# Rezoning Transportation Analysis

Petition Number: 2025-104

Date	Description
9-24-25	First Review (CM)
10-23-25	Second Review (CM)
11-20-25	Third Review (CM)

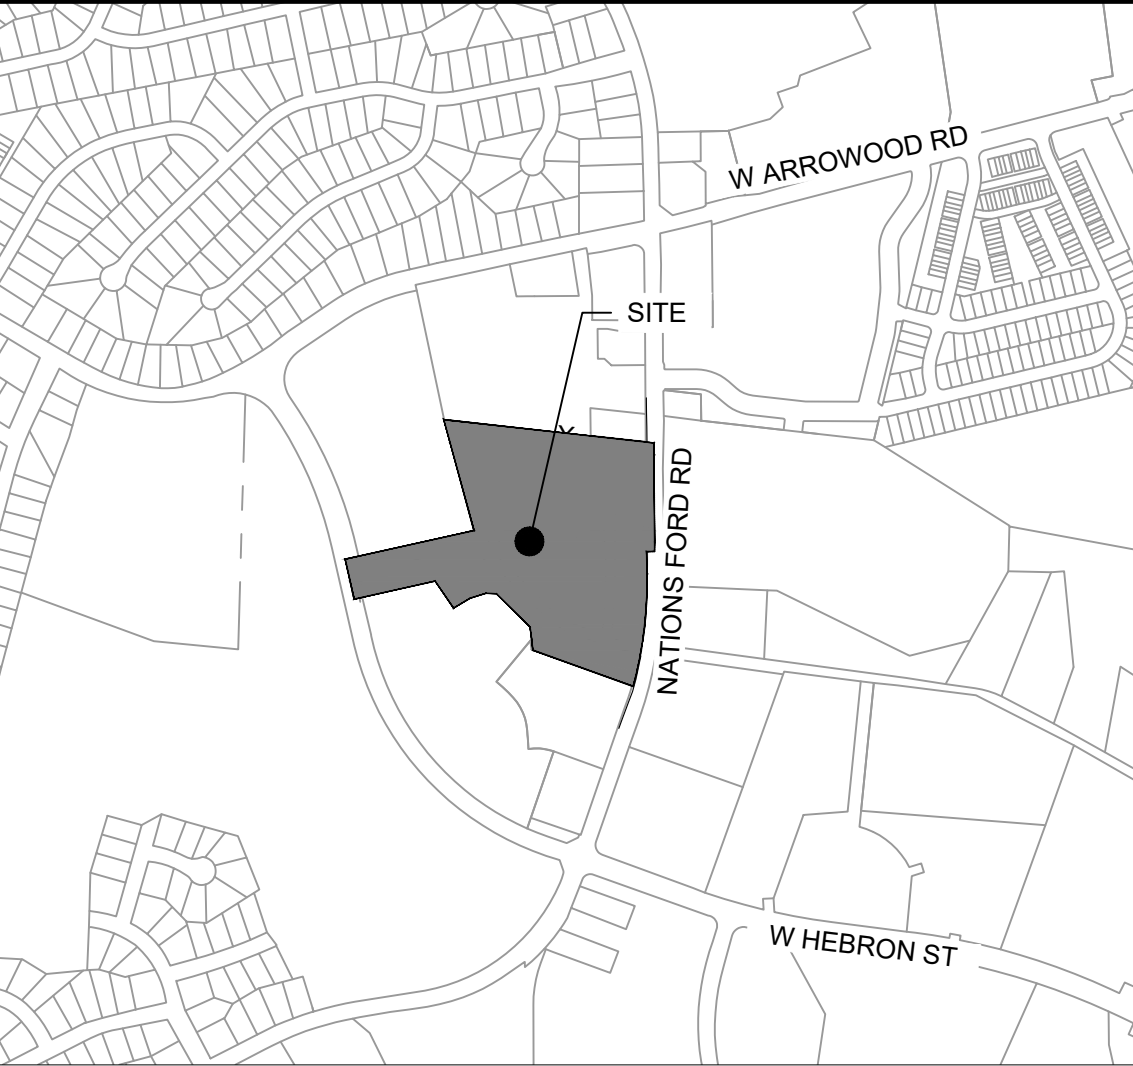
Label and dimension the curb and gutter from the centerline for each road on the site plan.

16. **New Comment 10.23.25:** Update the site plan road dimensions for Old Hebron Road, Road A, Road D, Road C to dimension based on standard 2.5ft curb and gutter instead of valley gutter, revise callout on site plan to reference 2.5-foot curb and gutter and not valley gutter. Please add the CLDSM detail on the site plan within the road labels for each (which will give flexibility per CLDSM to construct the appropriate section during permitting). Road B and C can remain without specific CLDSM label.
